Markup Summary

Cabinet Elevation

**Cabinet Elevation**

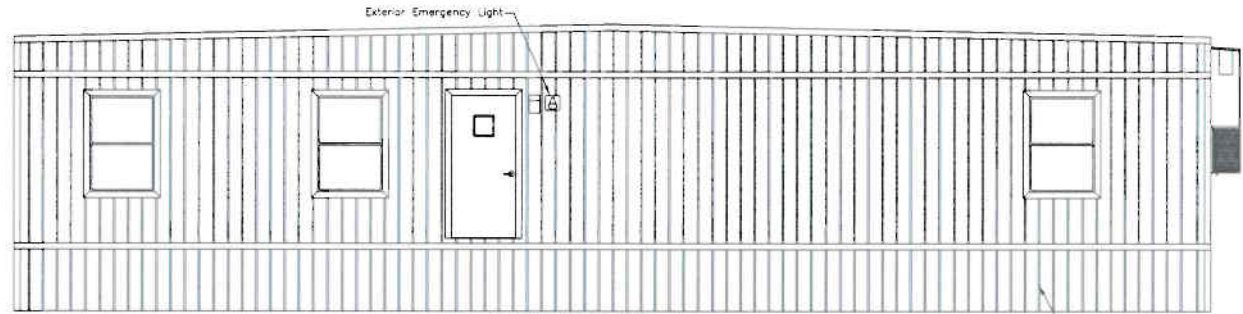
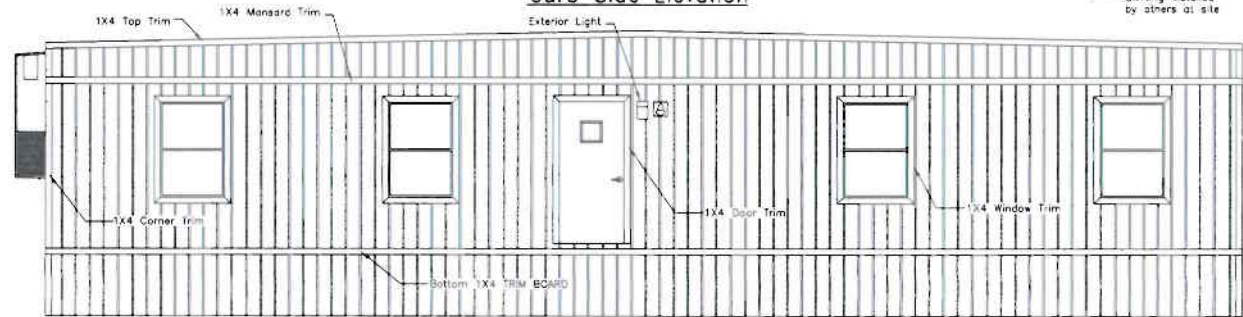
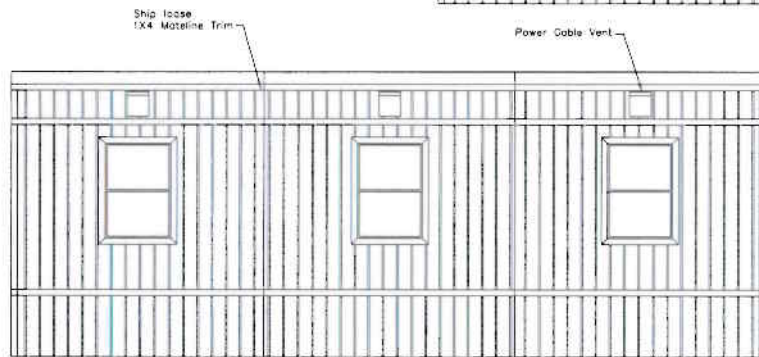
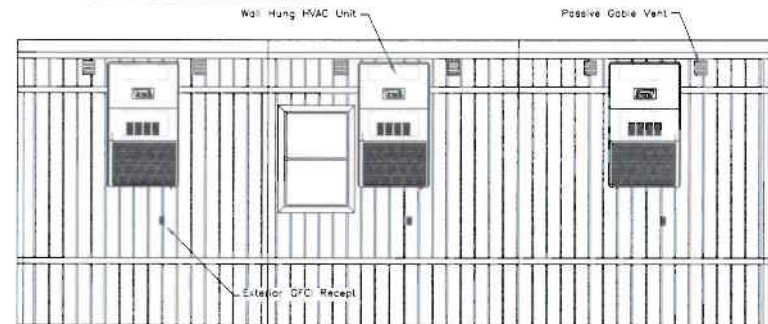
Include elevations for all structures to include height of structure and north/south/east/west elevations.
